Comments on the Applicant's Response to Deadline 3 Submissions [Part 9 - Noise] by William David Moore

Introduction

00:00 on 24/04/2021 to 00:00 on 25/04/2021

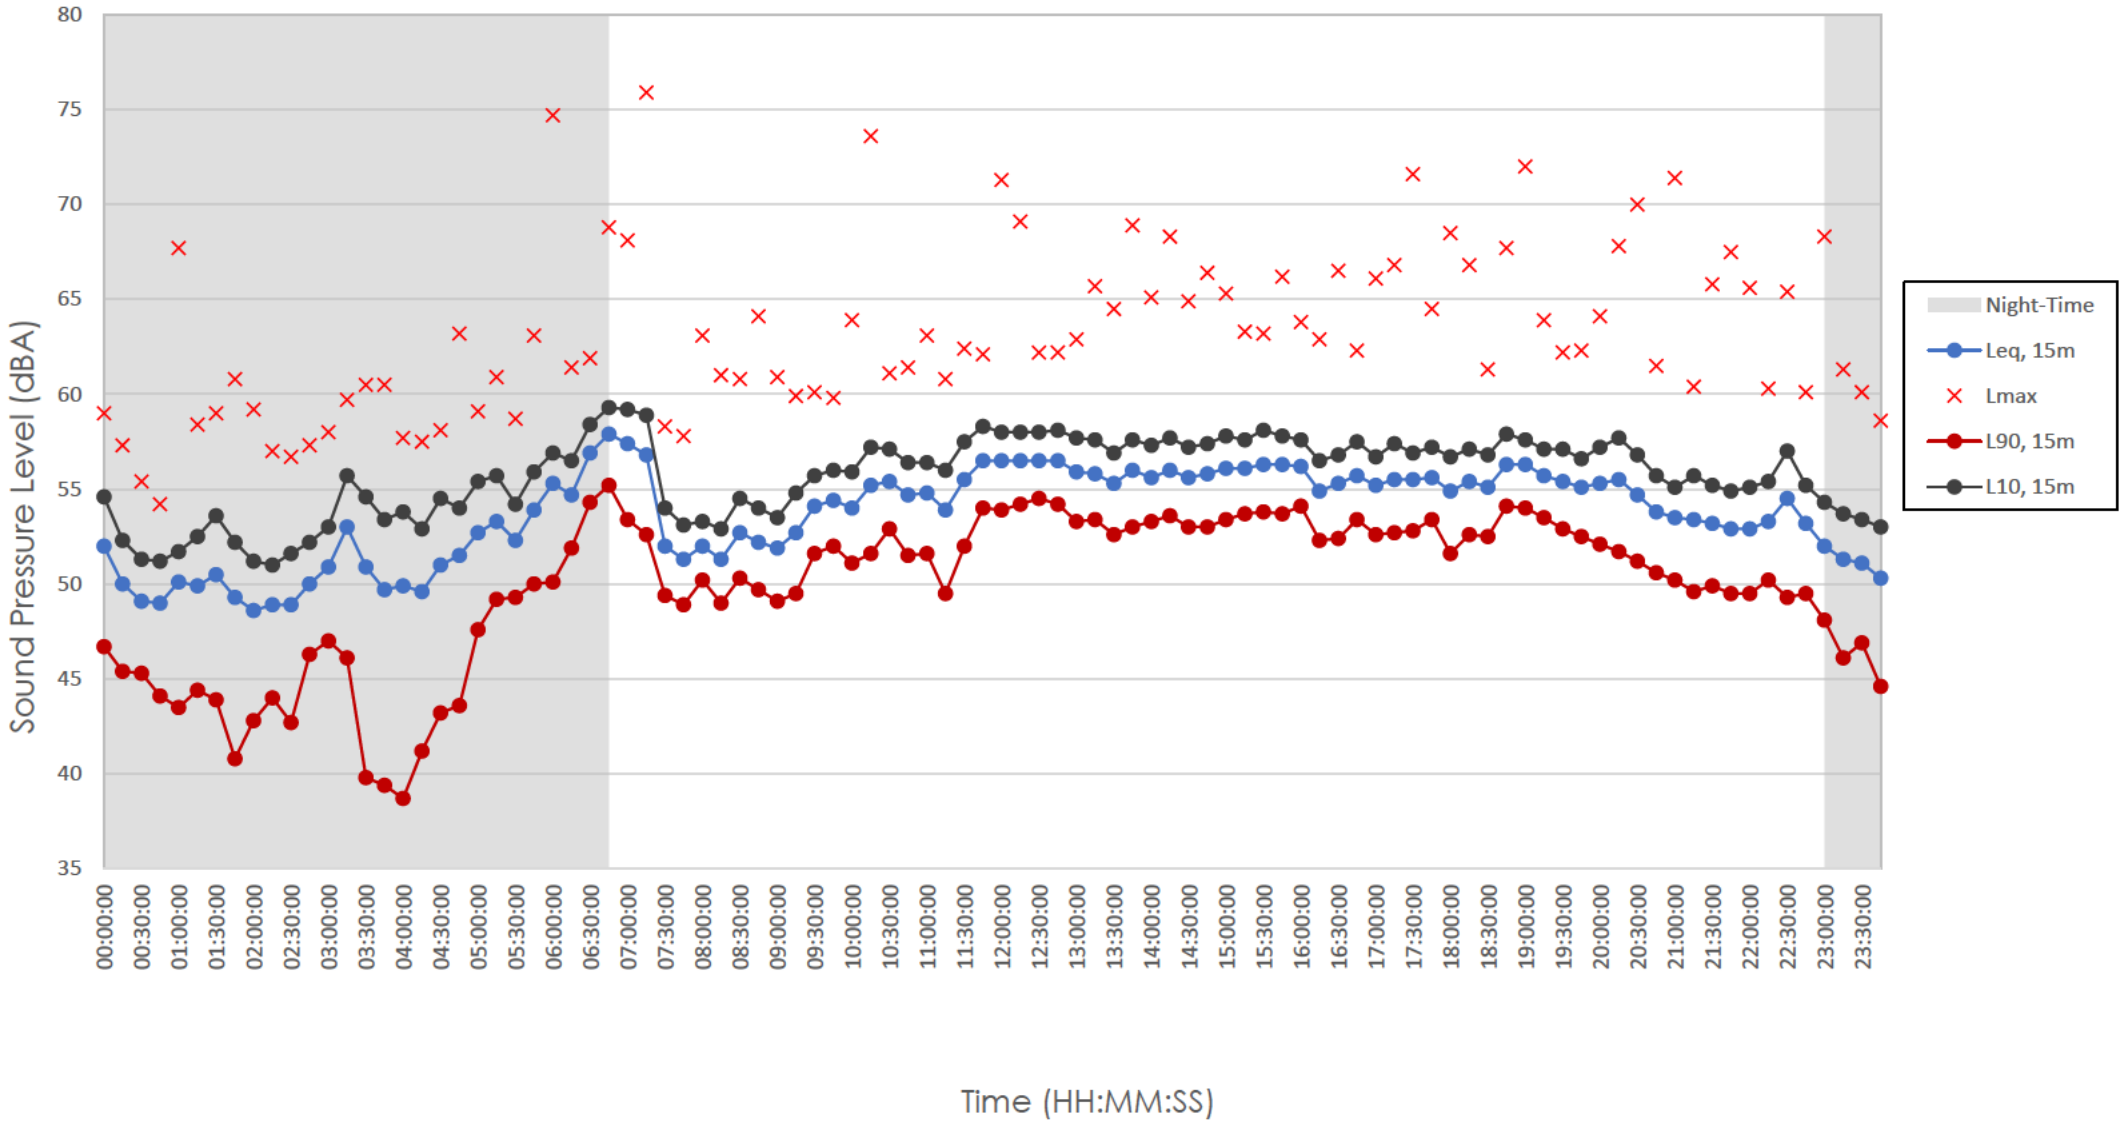
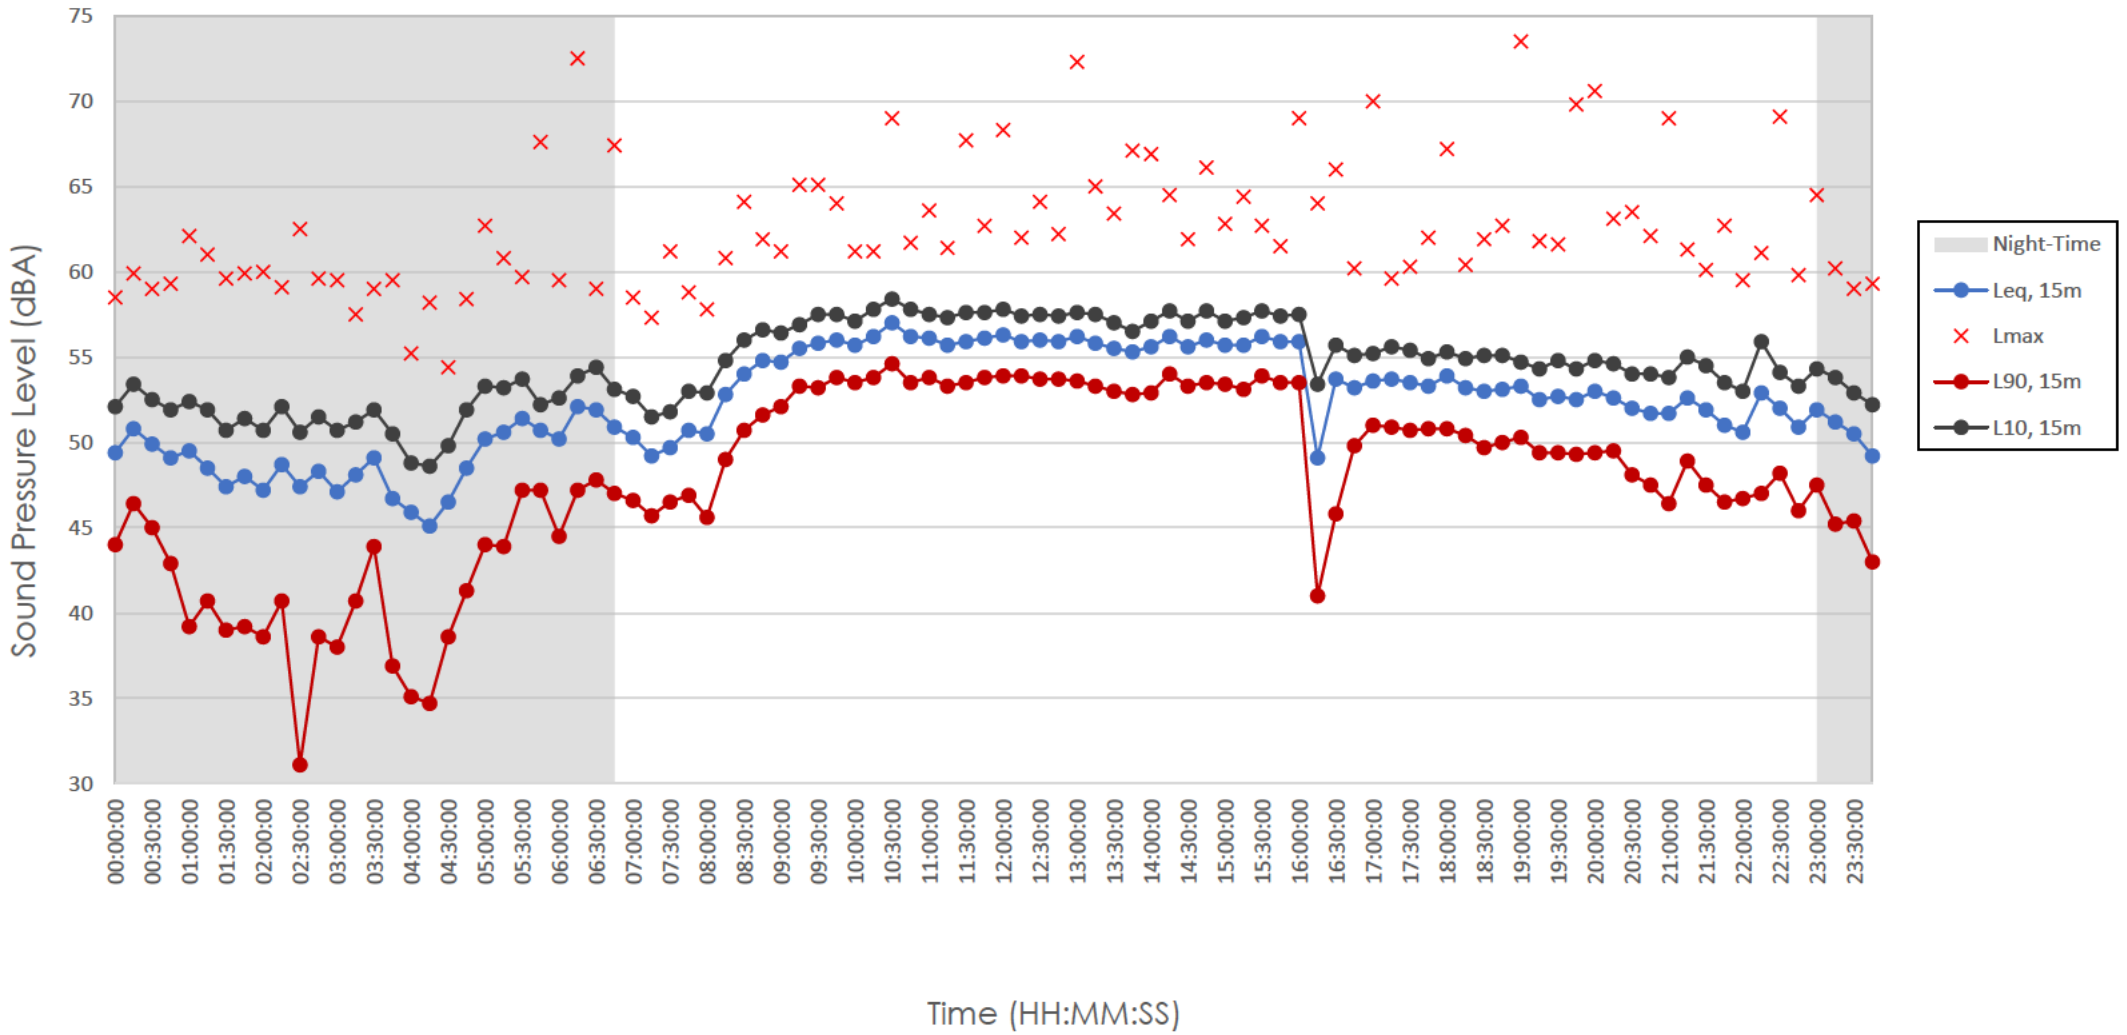
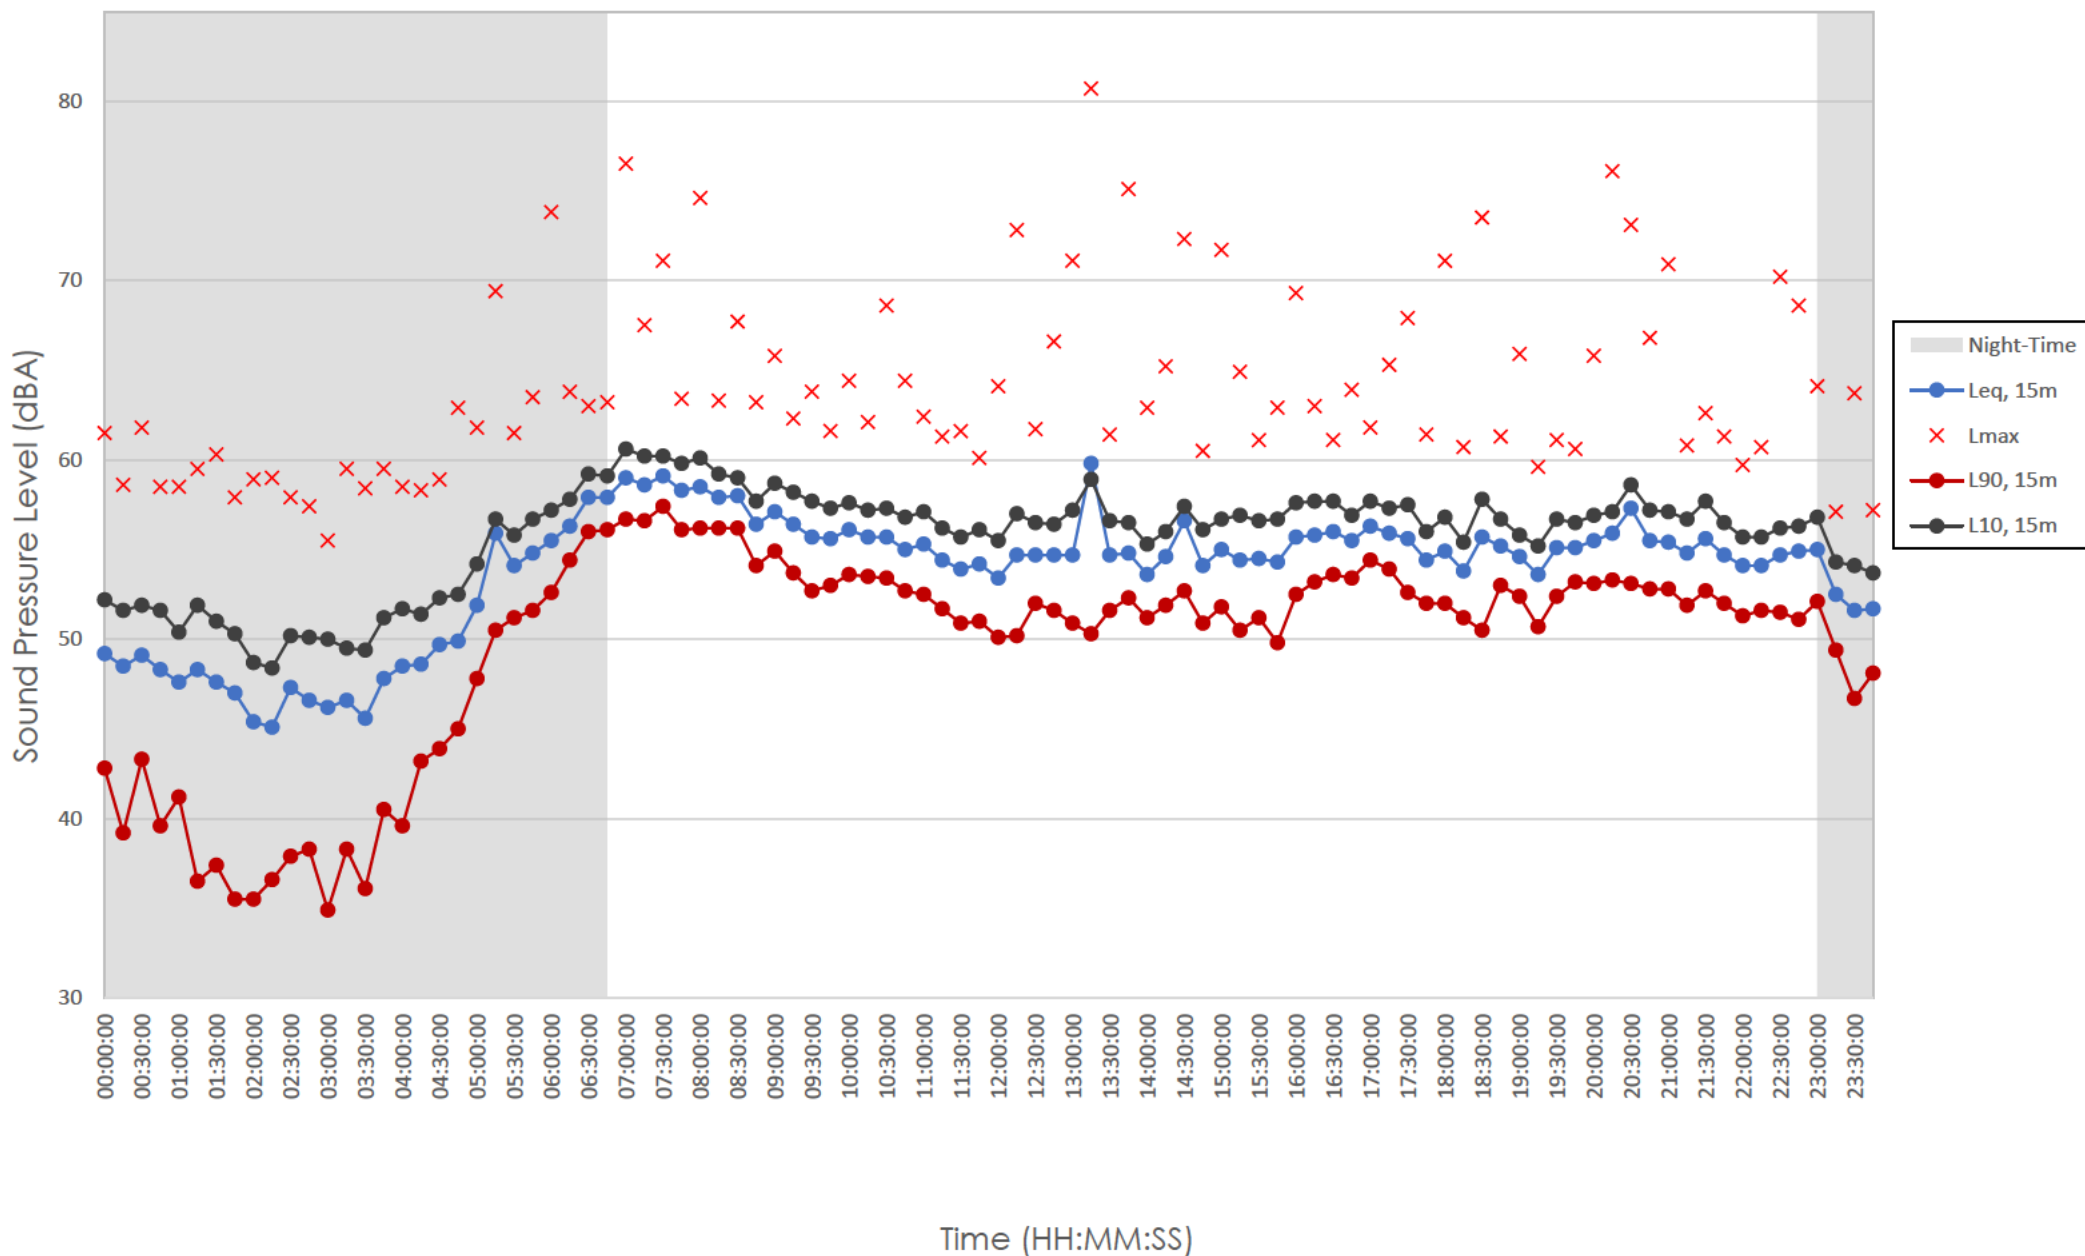
At NMP1, also in close proximity to the M69, the predicted daytime ambient sound levels were 5.4 dB above the levels measured and used in the report. The predicted night-time ambient sound levels were 6.4 dB above the levels measured and used in the report.
